**Re: Nuevo Atrisco**  
**7901 Central Ave. NW**  
**Traffic Circulation Layout**  
Engineer's/Architect's Stamp XX-XX-XX (K10-D058)

Based upon the information provided in your submittal received 05-05-23, the above referenced plan cannot be approved for Building Permit until the following comments are addressed:

SDP1-1

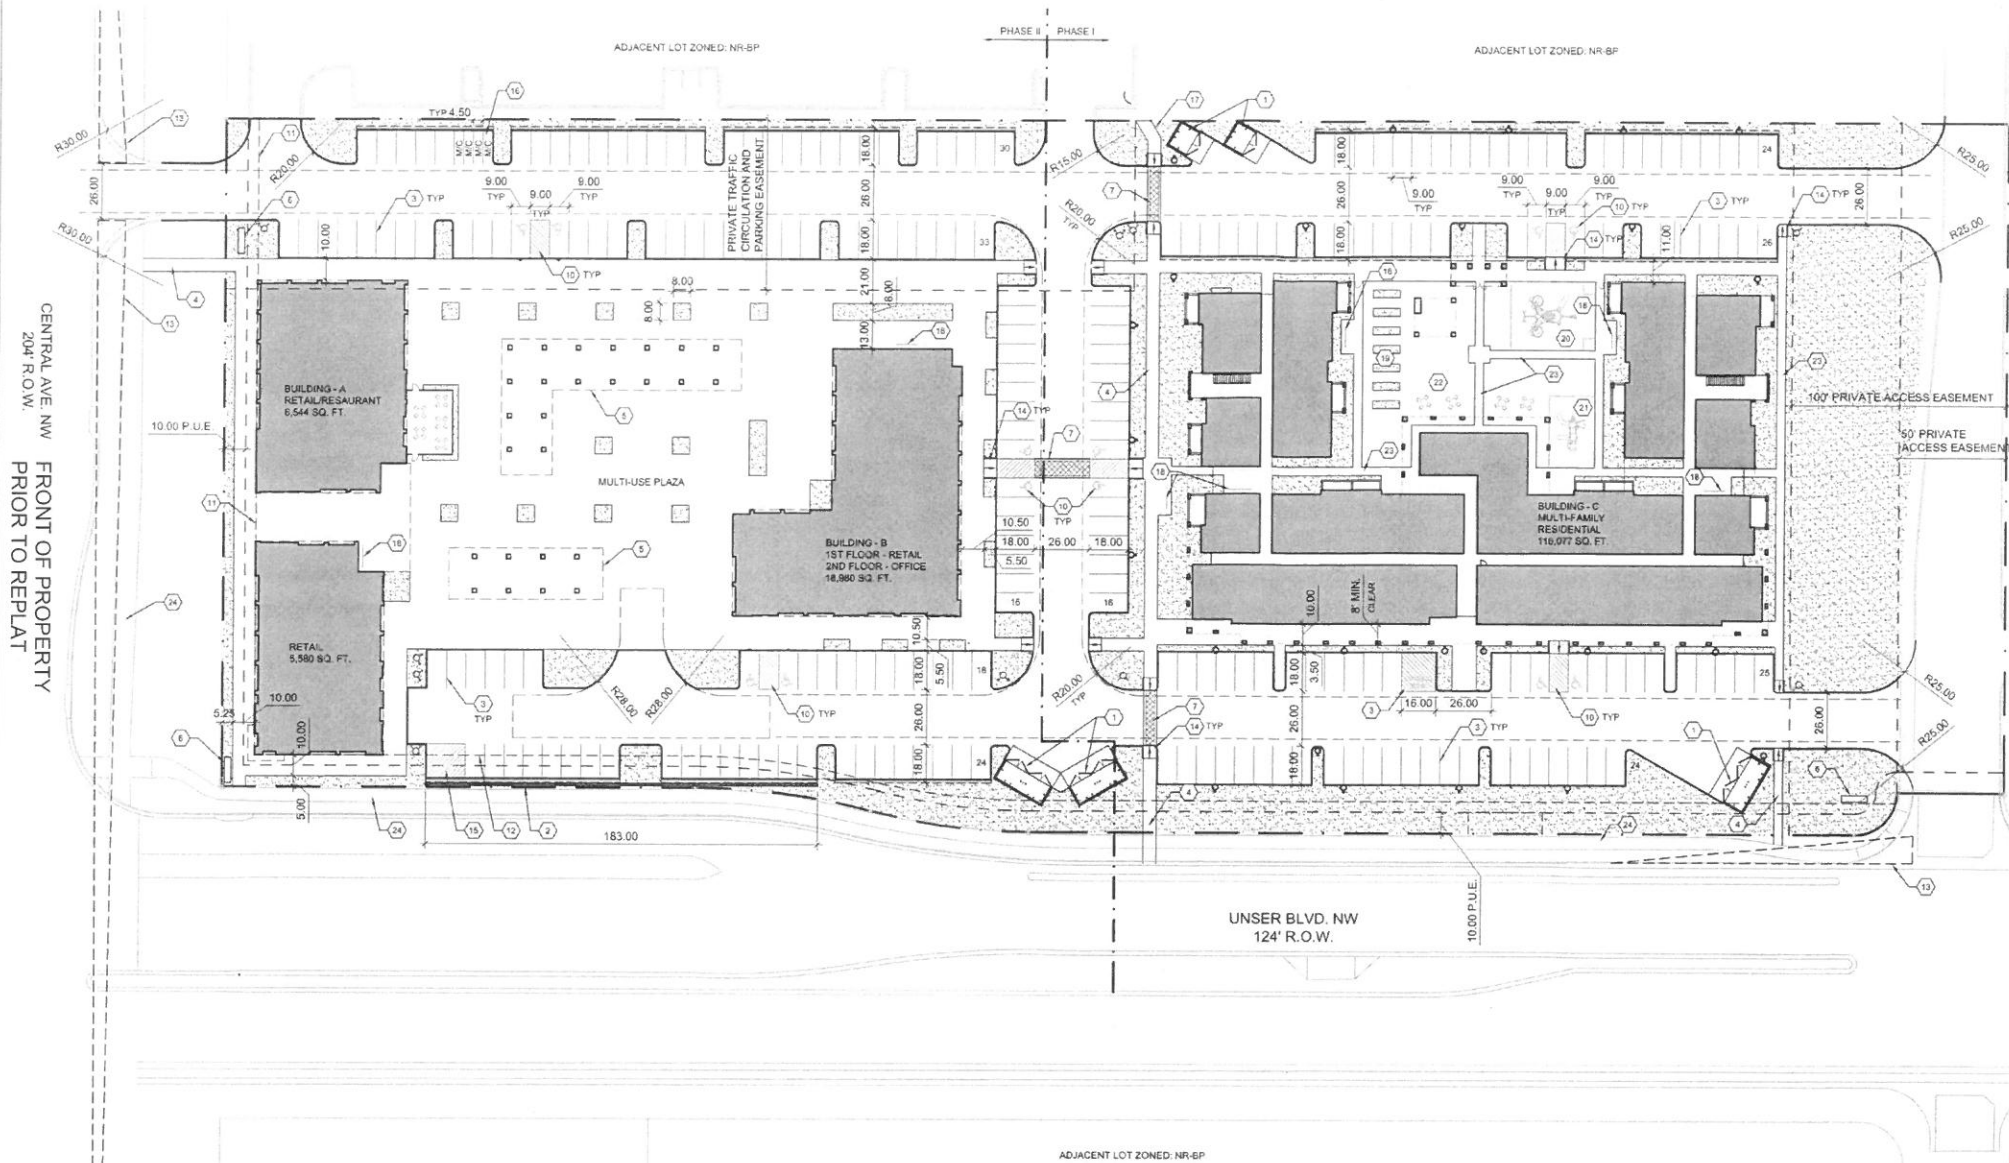
1. Please show a vicinity map showing the location of the development in relation to streets and well known landmarks.
2. The traffic circulation layout must be stamped, signed, and dated by an engineer or architect licensed in the state of New Mexico.

3. Identify the right of way width, medians, curb cuts, and street widths on Central Ave. and Unser Blvd.
4. The ADA accessible parking sign must have the required language per 66-7-352.4C NMSA 1978 **"Violators Are Subject to a Fine and/or Towing."** Please call out detail and location of signs.

5. The ADA access aisles shall have the words **"NO PARKING"** in capital letters, each of which shall be at least one foot high and at least two inches wide, placed at the rear of the parking space so as to be close to where an adjacent vehicle's rear tire would be placed. (66-1-4.1.B NMSA 1978)

6. The pavement marking "MC" should be shown in the opposite direction for motorcycles entering the parking space.
7. All bicycle racks shall be designed according to the following guidelines:

9. A 1-foot clear zone around the bicycle parking stall shall be provided.
10. Bicycle parking spaces shall be at least 6 feet long and 2 feet wide.
11. Please show the clear sight triangle on the site plan.
